The Drovers Solar Farm

Statement of Common Ground (SoCG) with Borough Council of King's Lynn and West Norfolk (Tracked)

PINS reference: EN0110013

Document reference: APP/5.20.2 (Revision 2)

The Drove, Swaffham Solar DCO	PROJECT
Ground Nesting Bird Strategy	TITLE
6806/GNBS2	DRAWING NO.
A/DO	REV
September 2025	DATE
LP/DO	QC

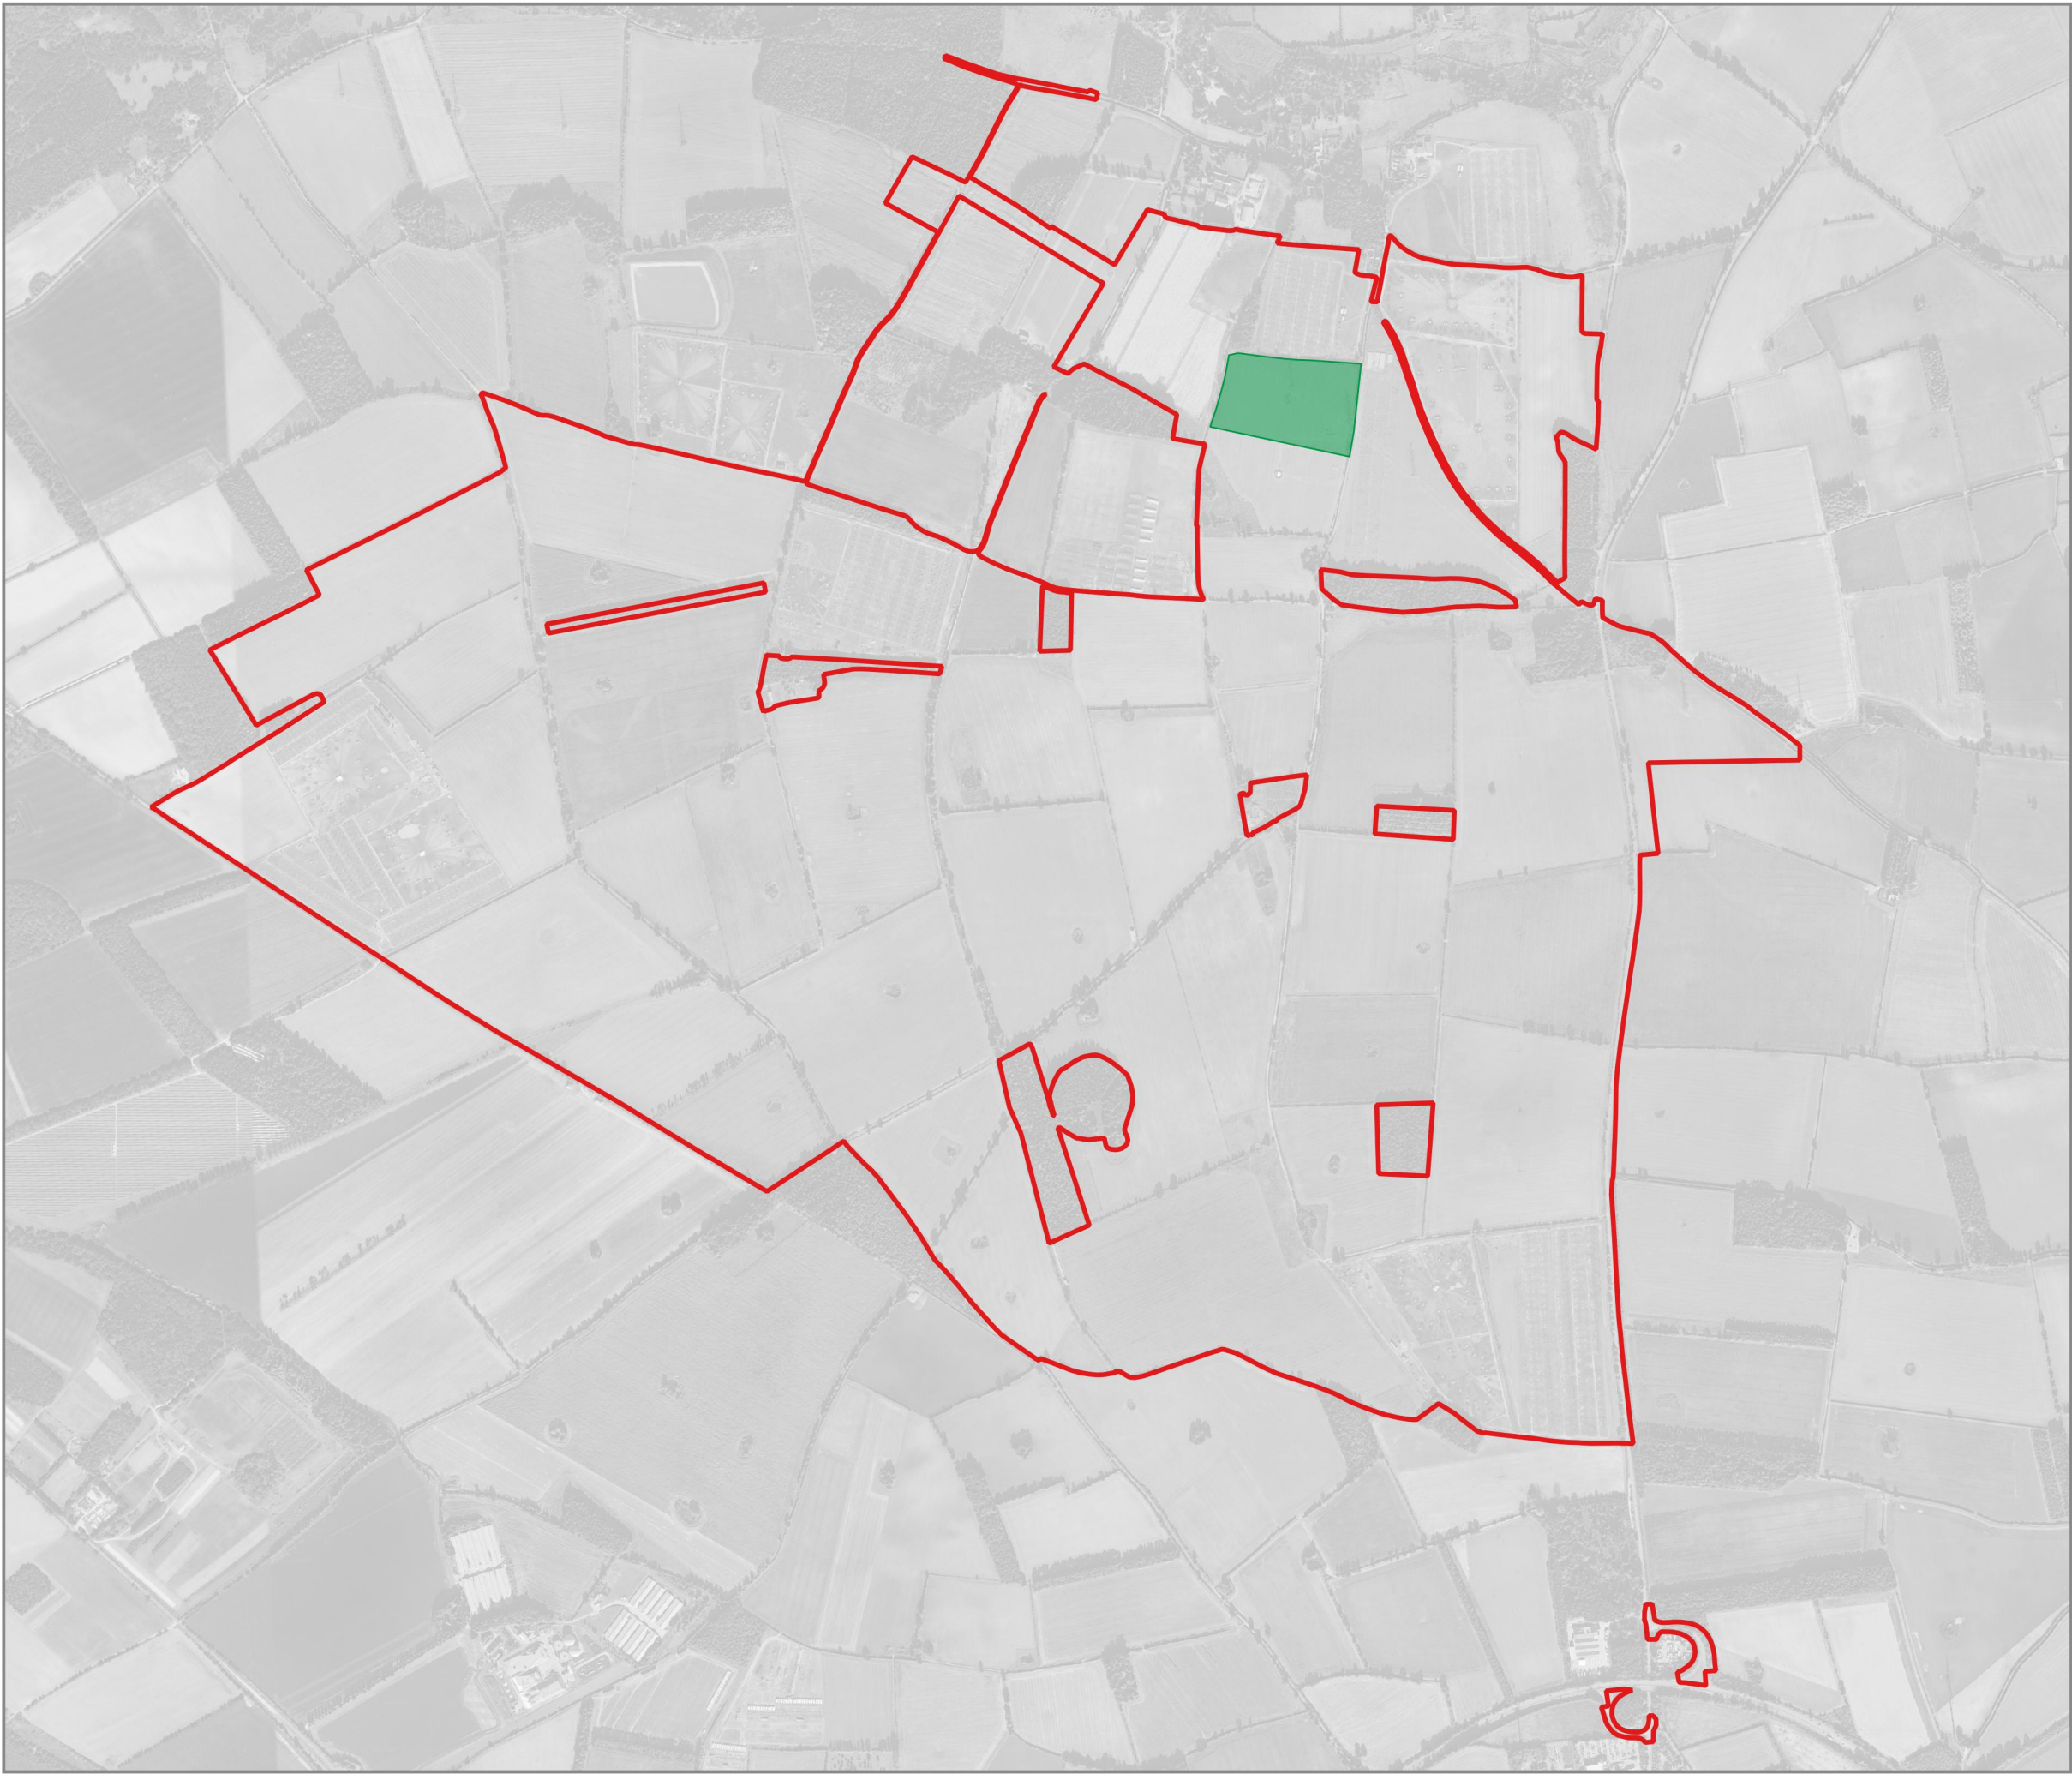
KLWN 3-4	Wintering Birds	The magnitude of impact on wintering bird populations would be negligible.	This is noted by the Applicant	Agreed
KLWN 3-5	Skylark Mitigation	The Council raise concerns regarding the methodology behind the plots provided for skylark mitigation at points 3.3.7 and 3.3.8 of the Local Impact Report- [REP1-076] [REP1-079] . The Council note that this point is under discussion whilst their ecologist considers further.	As set out within the ES Appendix 7.3: Proposed Mitigation Strategy for Ground Nesting Birds Requiring Open Habitats [APP-149] , the methodology used in relation to calculation of Skylark mitigation follows the approach set out within published methodology (Fox, 2022). As set out, the initial input figure of 117 pairs has been used in relation to the development footprint (i.e. excludes the 4 pairs within field 32 which is outside of the Scheme's boundary but includes the existing pairs within fields 33 and 35 and as such these are taken into account). In relation to territories that could be absorbed within 75m of the development edge habitats, in line with	Under Discussion

the published methodology this relates to an increase in capacity over the existing use due to increased foraging habitat in proximity to the edges of the development and accordingly, the exclusion of the existing pairs within field 32 from the calculations is no different from that within surrounding fields elsewhere, which would be anticipated to support a baseline of Skylark usage, and therefore consistent with the published methodology.	
KLWN 3-6	Impact on Protected Sites	Subject to compliance with the outline Construction Traffic Management Plan and outline Construction Environmental Management Plan, the Council raises no objection in regard to impacts on Protected Sites.	This is noted by the Applicant	Agreed
KLWN 3-7	Request for Habitat Monitoring and Management Plan	The Council request for a Habitat Monitoring and Management Plan to be secured through the DCO, notwithstanding the outline LEMP already submitted.	This is noted and agreed by the Applicant	Agreed
